FOREST HEIGHTS ESTATES GRADING & EROSION CONTROL PLANS

**FOREST HEIGHTS CIRCLE
GRADING & EROSION CONTROL PLAN**
TITLE SHEET

FOREST HEIGHTS CIRCLE GRADING & EROSION CONTROL PLAN
GENERAL NOTES AND EROSION CONTROL DETAILS

STORMWATER ENTERPRISE		EROSION PROTECTION ABOVE CULVERT OUTLETS	
ISSUED: 10/7/19	REVISED: 8/19/2020	DRAWING NO: 900-EPC

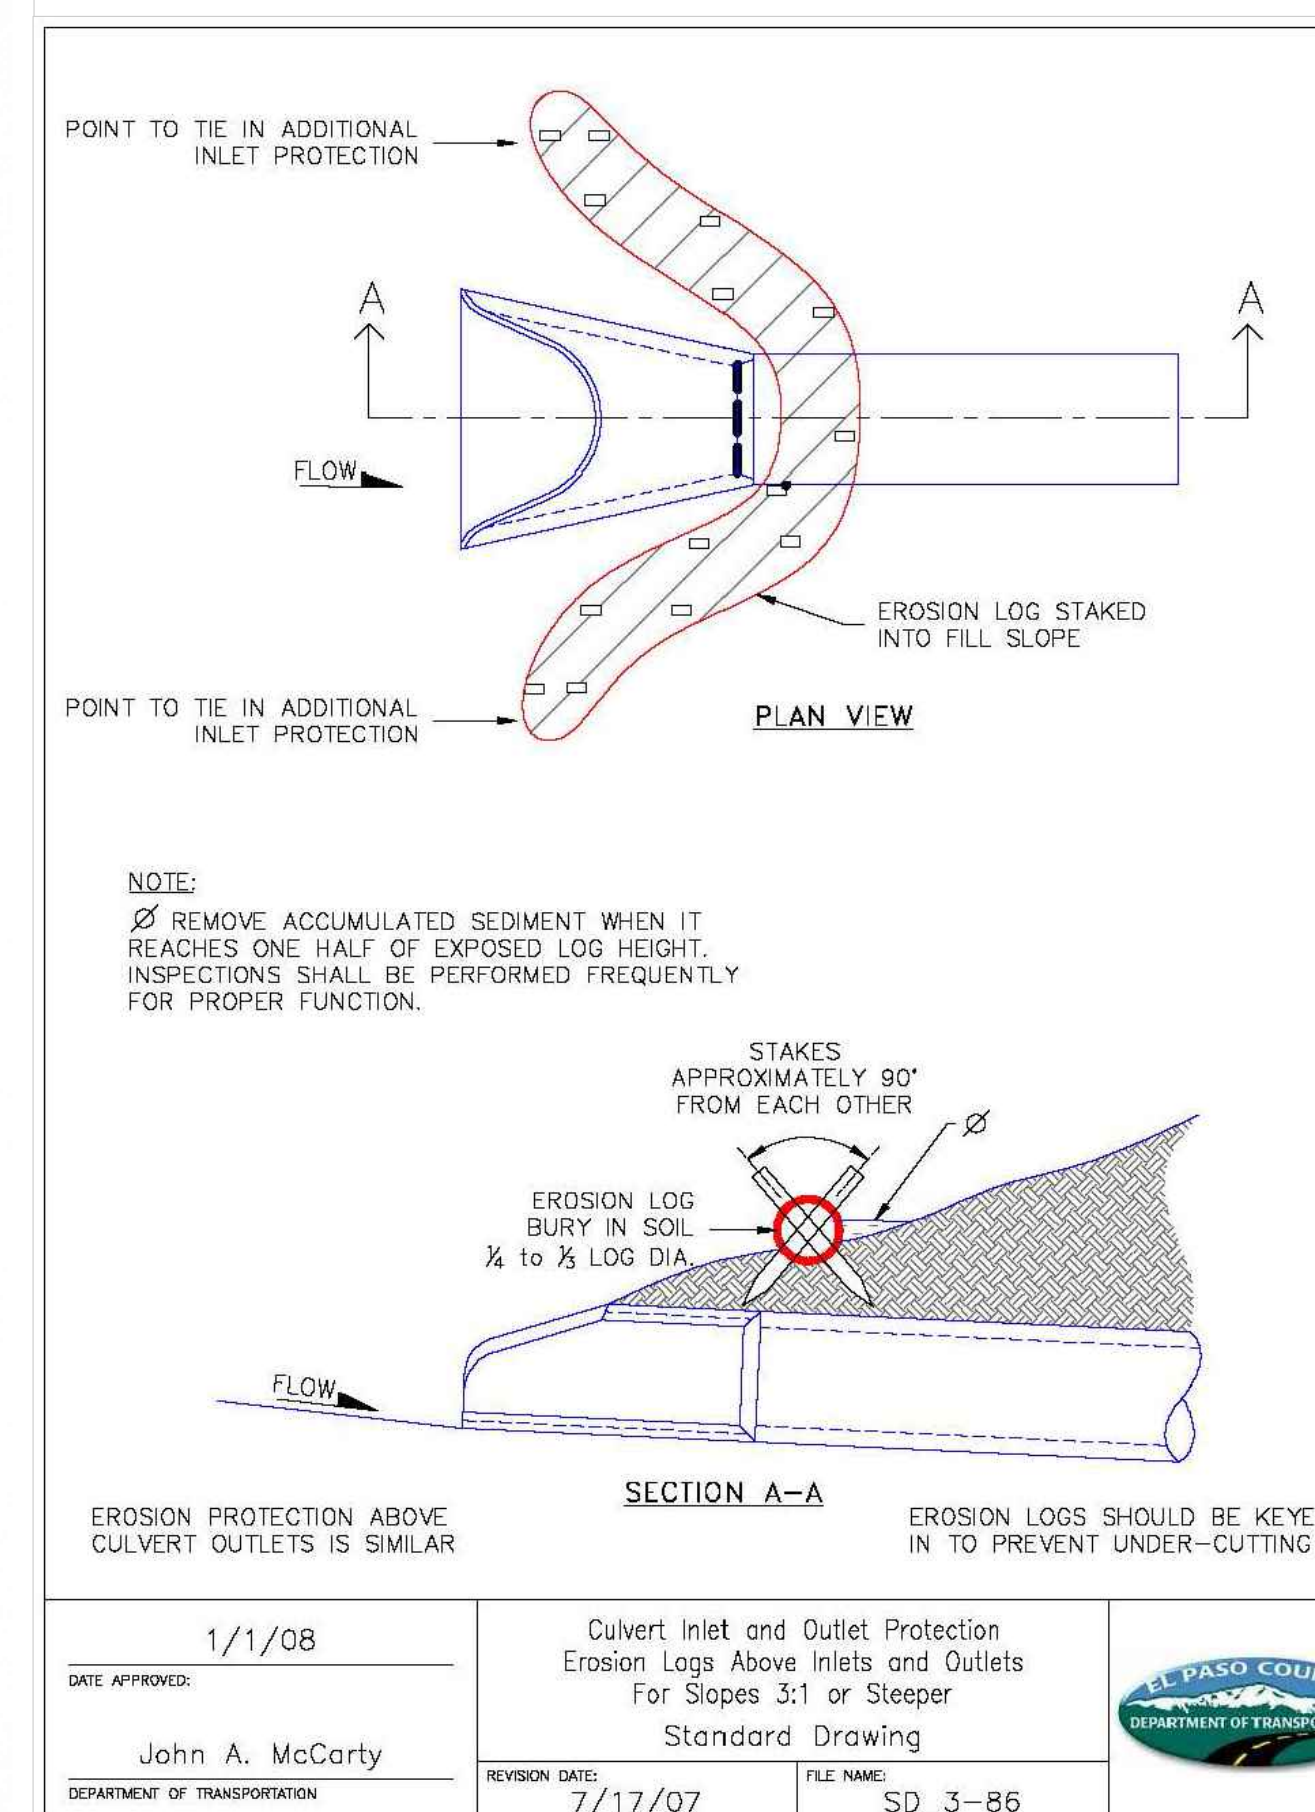
Comment generated due to changes in the document from previous submittal, per my comment on pdf pg 93 of the v3 FDR:
It is unclear how these grass species compare to those in DCMv1 Chap 10.7, Table 10-4. Please clarify with a note here or via a discussion in the FDR what velocity and slope is permissible with these species since these are not shown on Table 10-4.

With Review #2 and #3, I asked for the VTC detail to be revised/replaced to meet our EPC criteria. With this Submittal #4, the detail was removed completely. A detail is needed since a VTC is still shown on the GEC Plan below. So please add in an acceptable VTC detail with a min 75ft length. For reference, below is my Review #3 comment:

If a VTC is added to the plans above, add a VTC detail to this sheet. And make sure to use a EPC approved VTC detail (VT-1 and VT-2 in DCMv2, Chap 3.3) or revise other detail (which usually have 50ft length) to be 75ft min length.

MATCH LINE  
STA 11+50

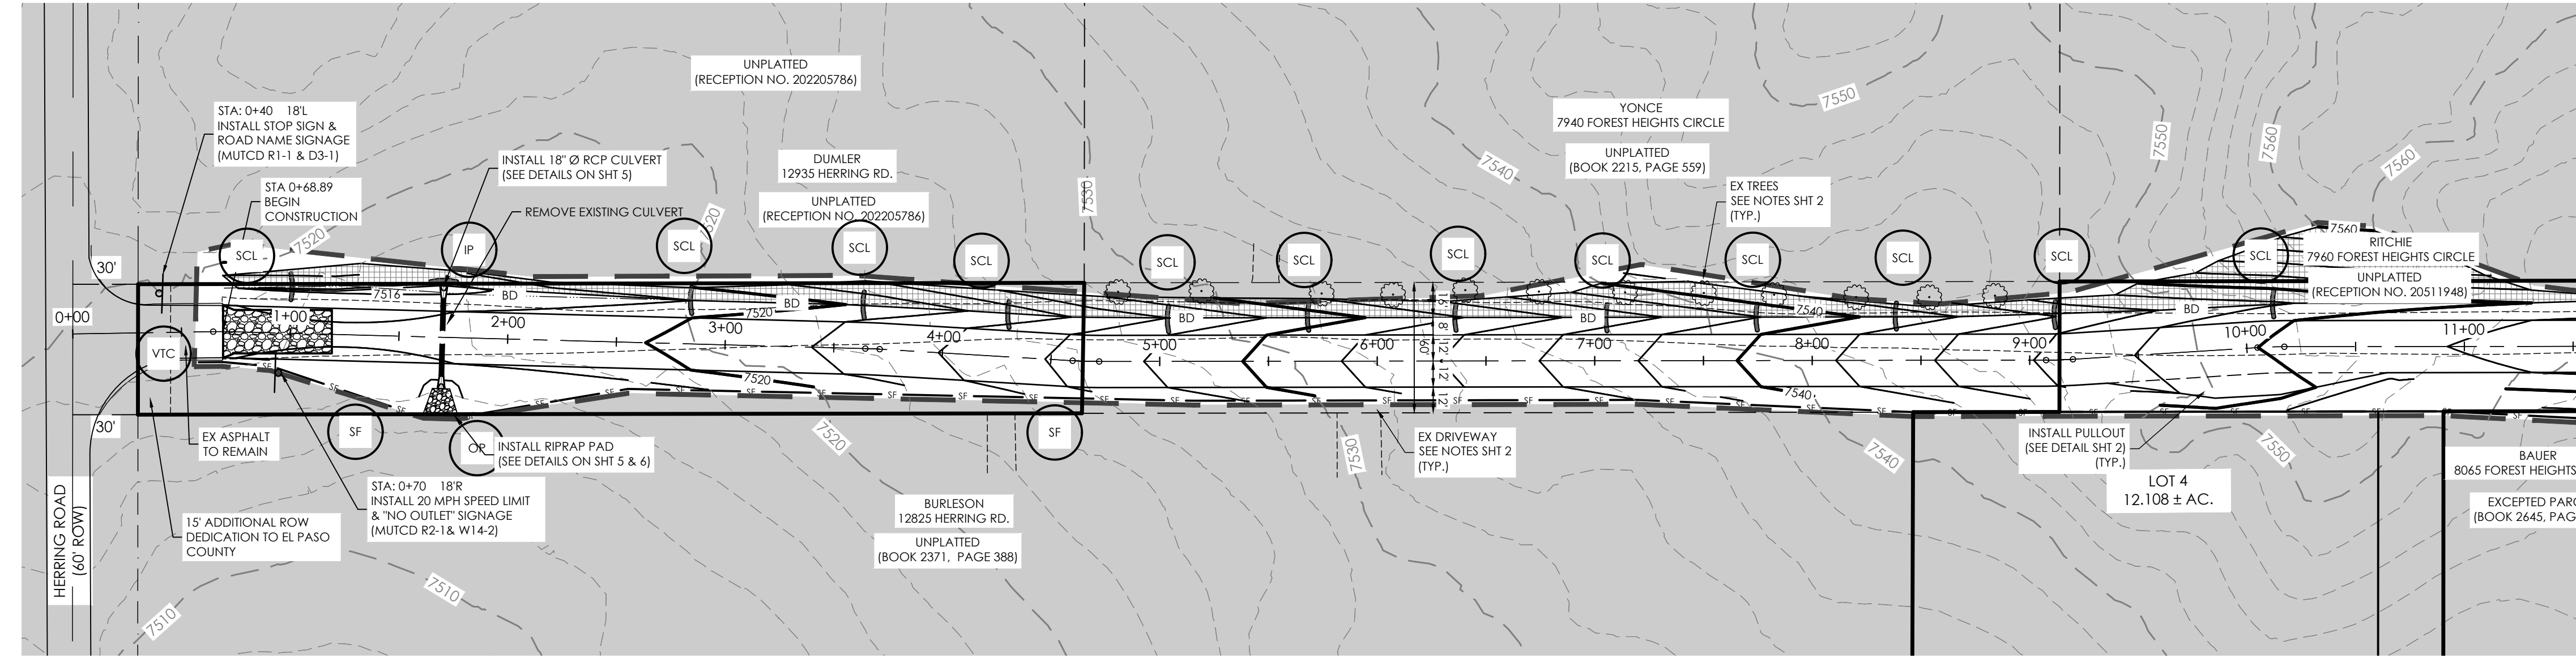
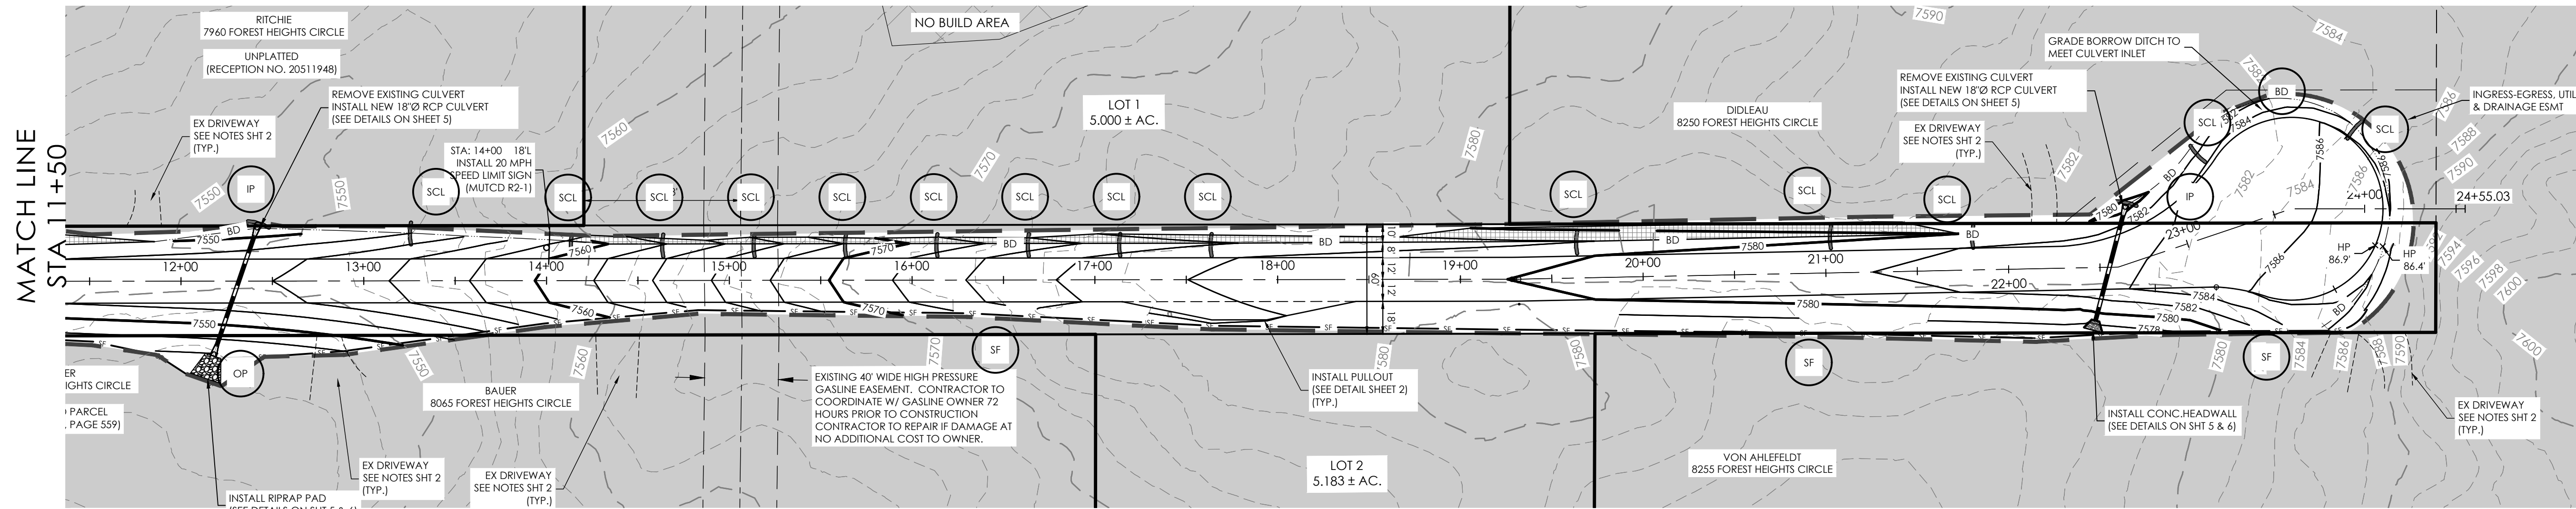
Show these approx locations of building footprints and driveways on FDR drainage map.

With this submittal, all proposed topo was "turned off" so is not visible. Please include all proposed topo on these plans with the next submittal.

Unresolved comment from Review 3:
Show location of driveway culverts.

Unresolved comment from Review 3:
Show approx location of wetlands as shown in the drainage map on the last page of the drainage report.

This area was not shown with the last submittal and is not shown in the FDR. Please revise to remove discrepancy.
